Department of Transportation

SH83/Walker Rd
El Paso County

re: Monument Academy/YMCA_SH83Walker - Aug2019_Site Development Plan - EA18206_PPR199 -
REVISED for Hydraulic comments

ENLARGED DETENTION POND M3 PLAN

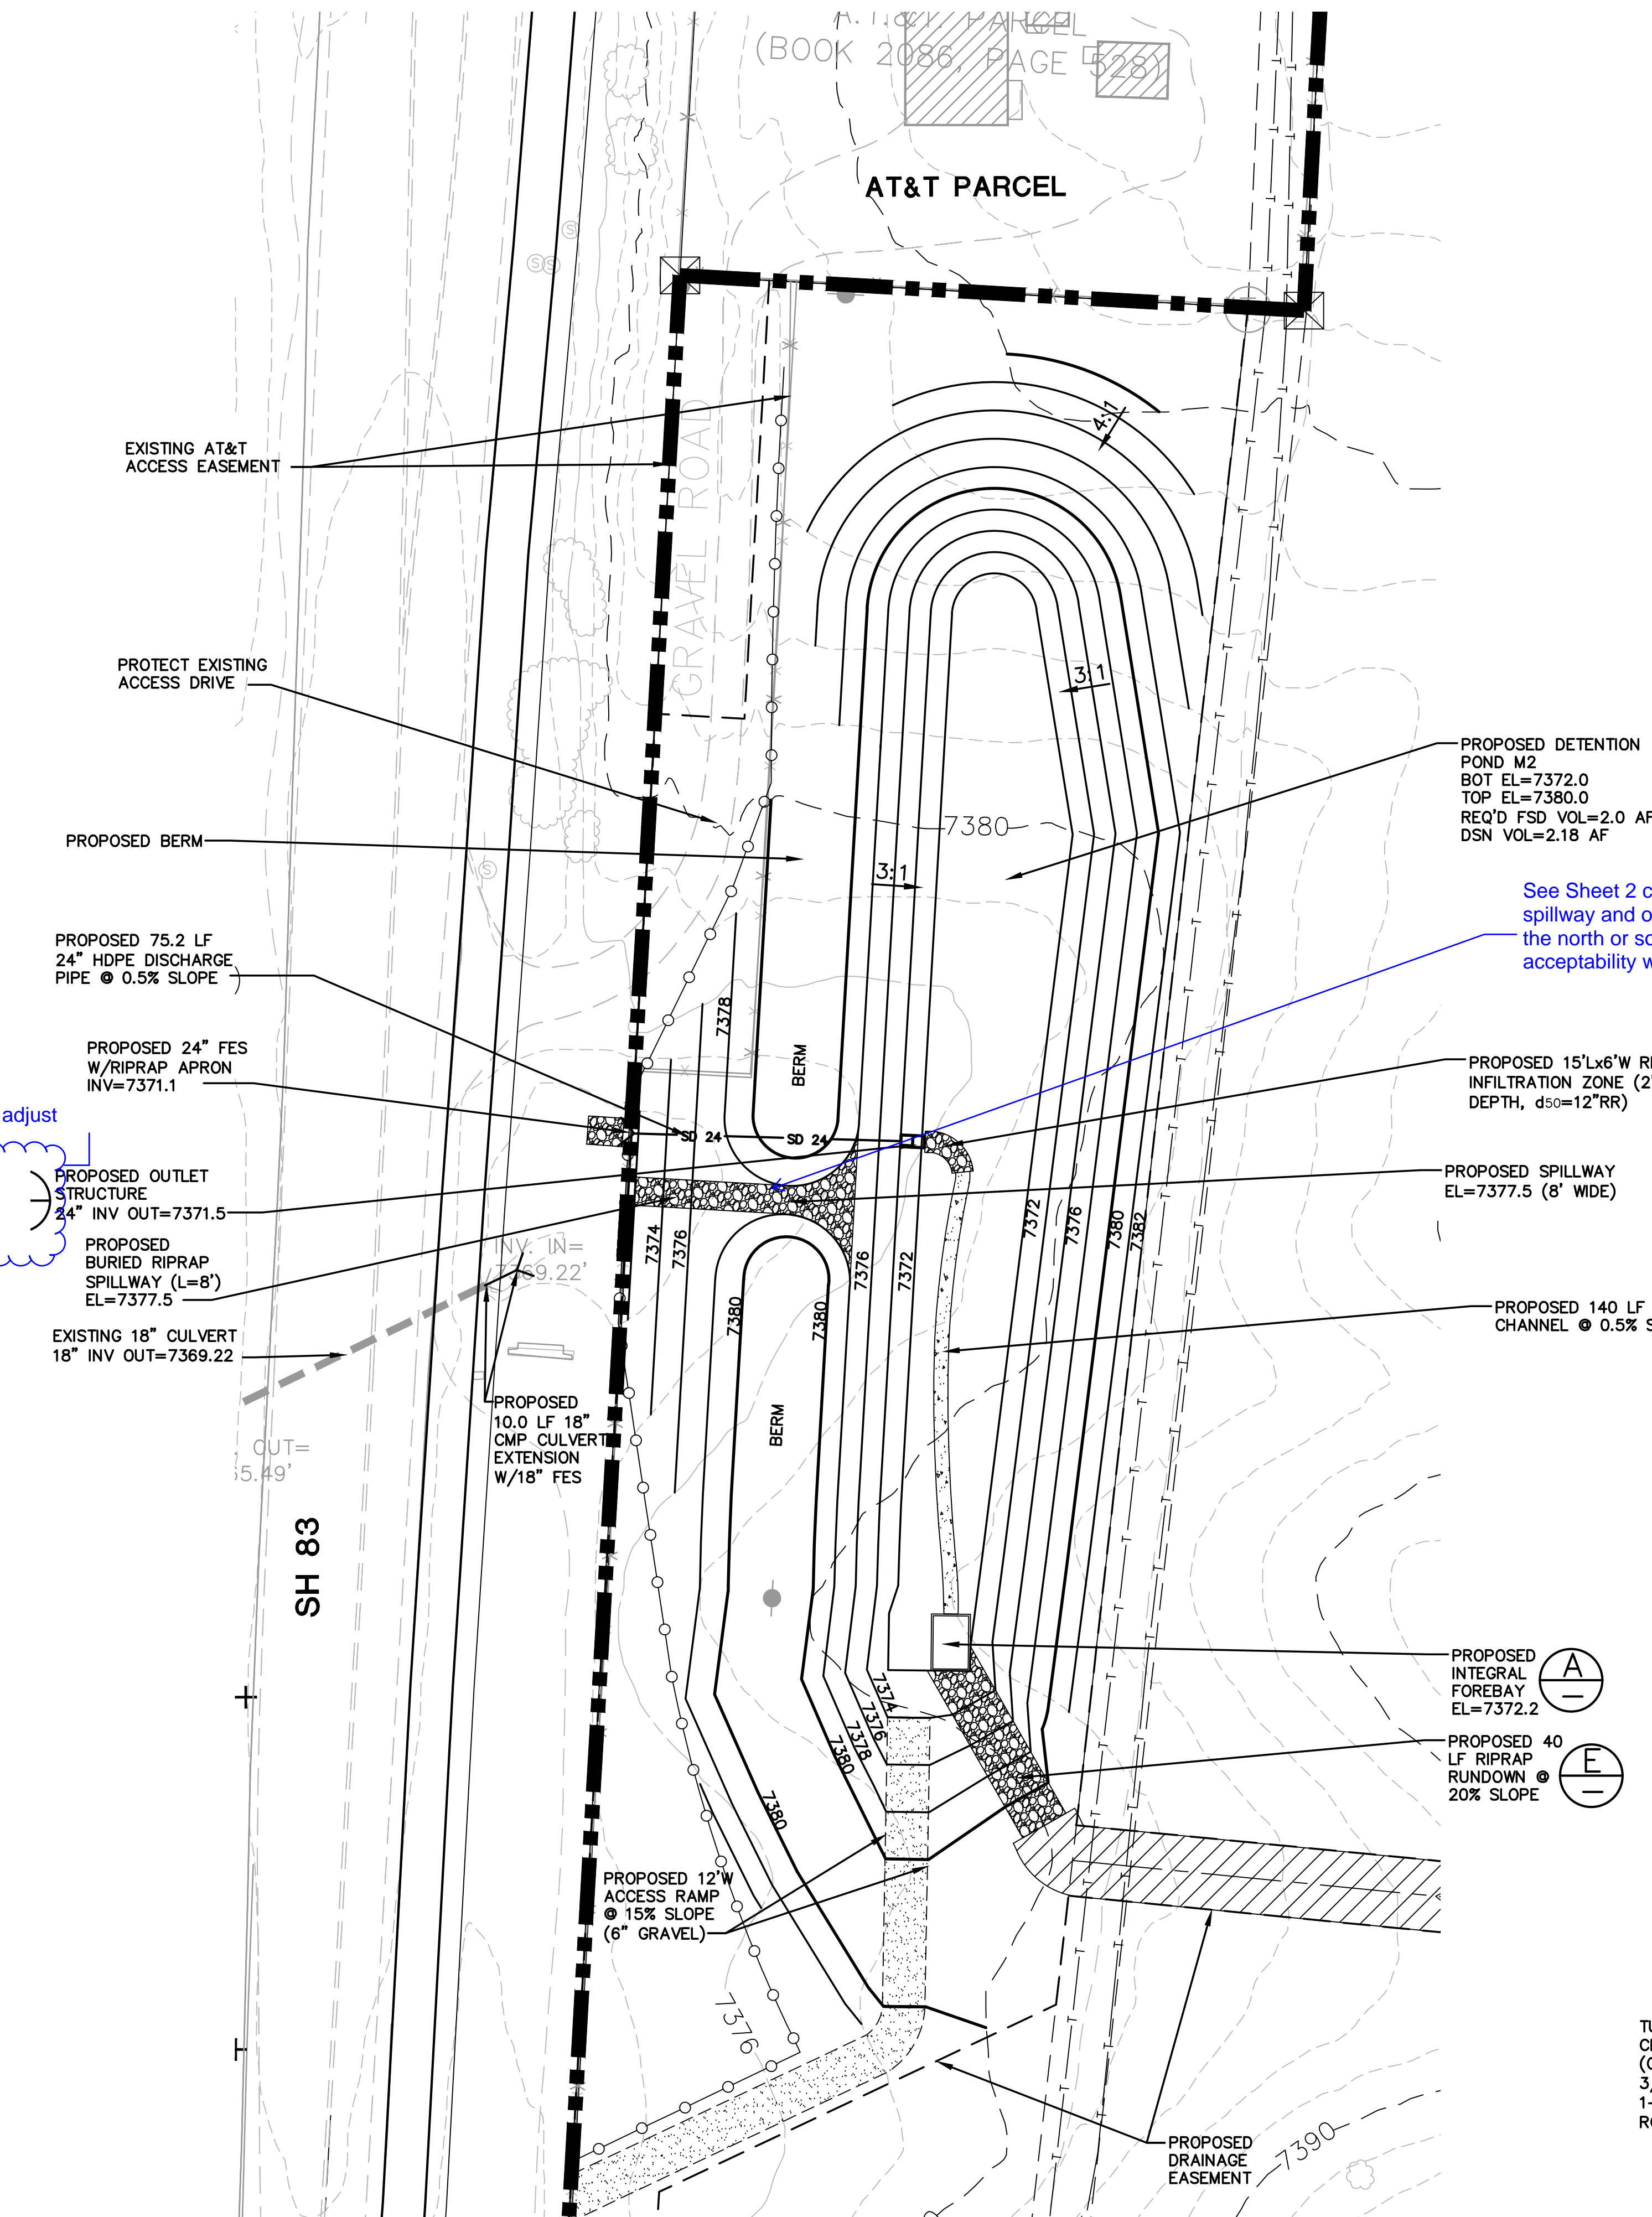
- d. Drainage Report/Grading Plan, Pond M3 - Pond spillway elevation given on pond sheet, but grading does not reflect spillway. At the height show, this pond exceeds 10' in height and could be classified as a jurisdictional dam. Please show grading of spillway to avoid this. Also, please provide detail of spillway and material used. Use of UDFCD spillway design guidance recommended. Not verified in the latest drainage submittal, please address and communicate back to CDOT.**

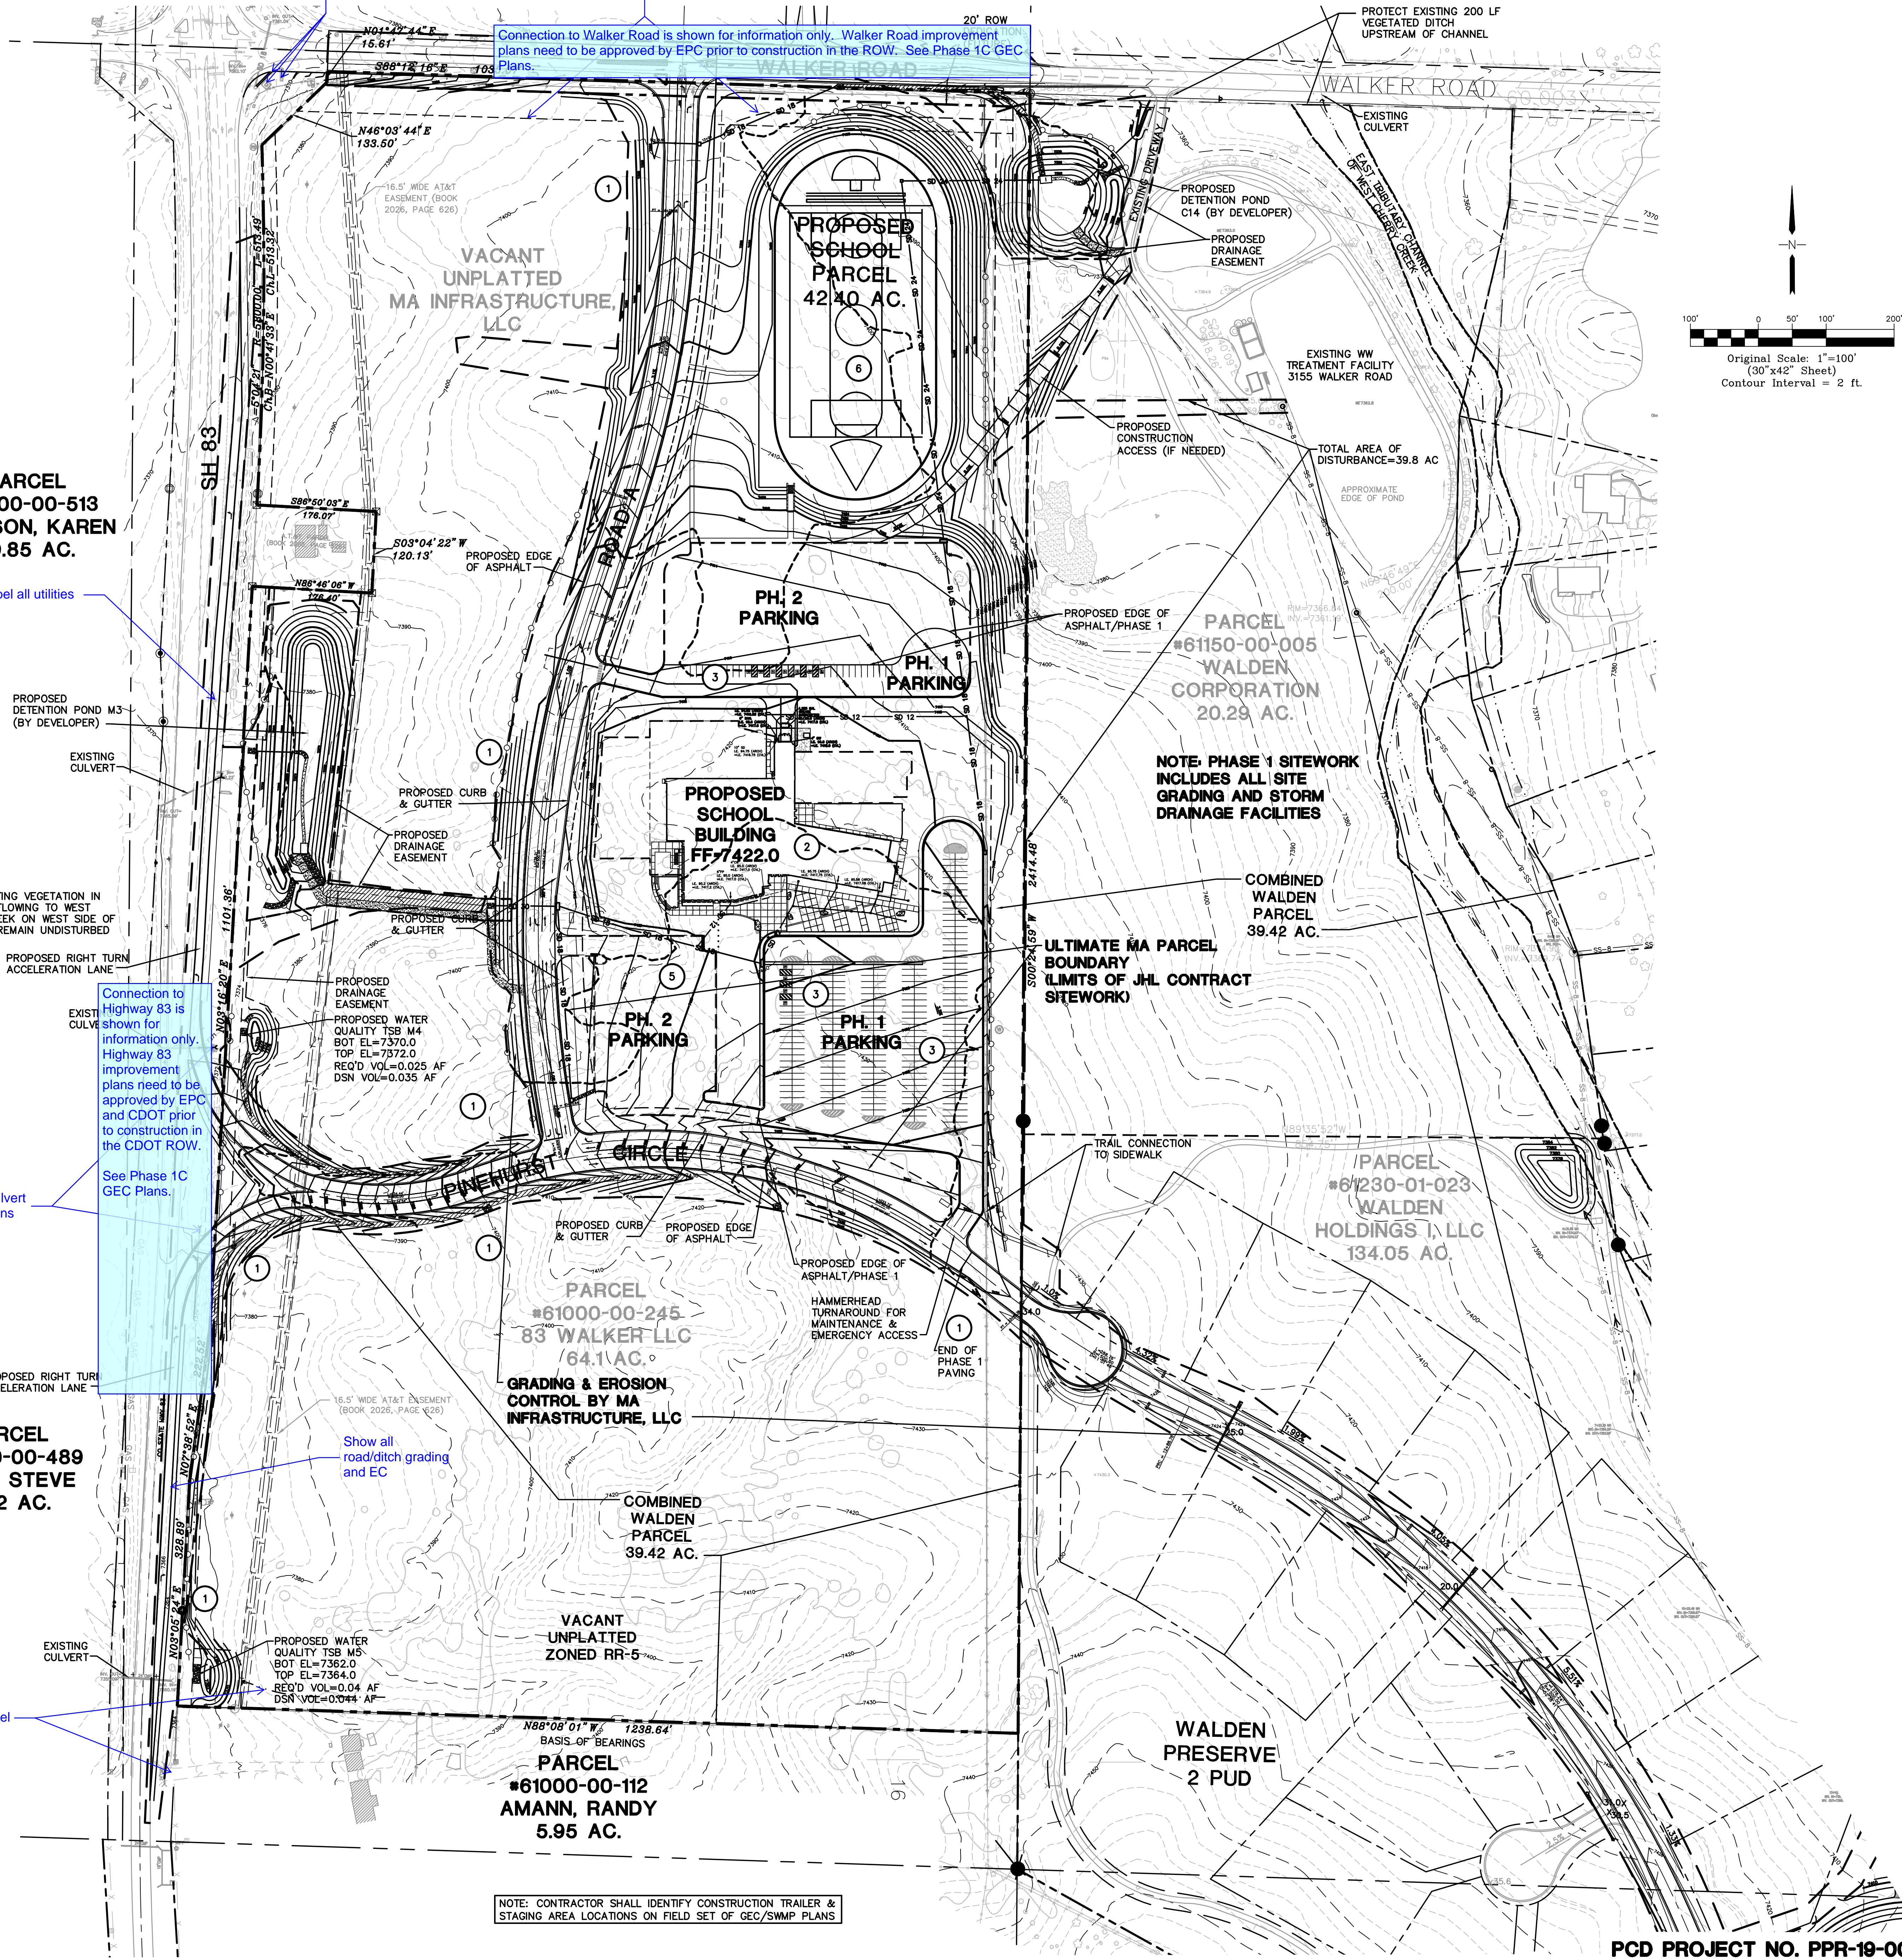
- i. Provide engineering details on the proposed collar joining the proposed extension of the existing CDOT 24" cross culvert.
- j. Extend proposed riprap at the pipe on the southern end of the project that discharges to CDOT ROW all the way to the proposed extension of the existing CDOT 24" CDOT cross culvert.

- k. Provide engineering details on the proposed collar joining the proposed extension of the existing CDOT 24" cross culvert.
- l. Include in the construction work, clean existing 24" culvert that receives outflow from Pond M3.

- m. Extend proposed riprap at outlet of Pond M3 to connect to the new extension of the existing CDOT cross culvert.
- n. Drainage plans not provided. Type of pipe for culvert extensions not noted.**
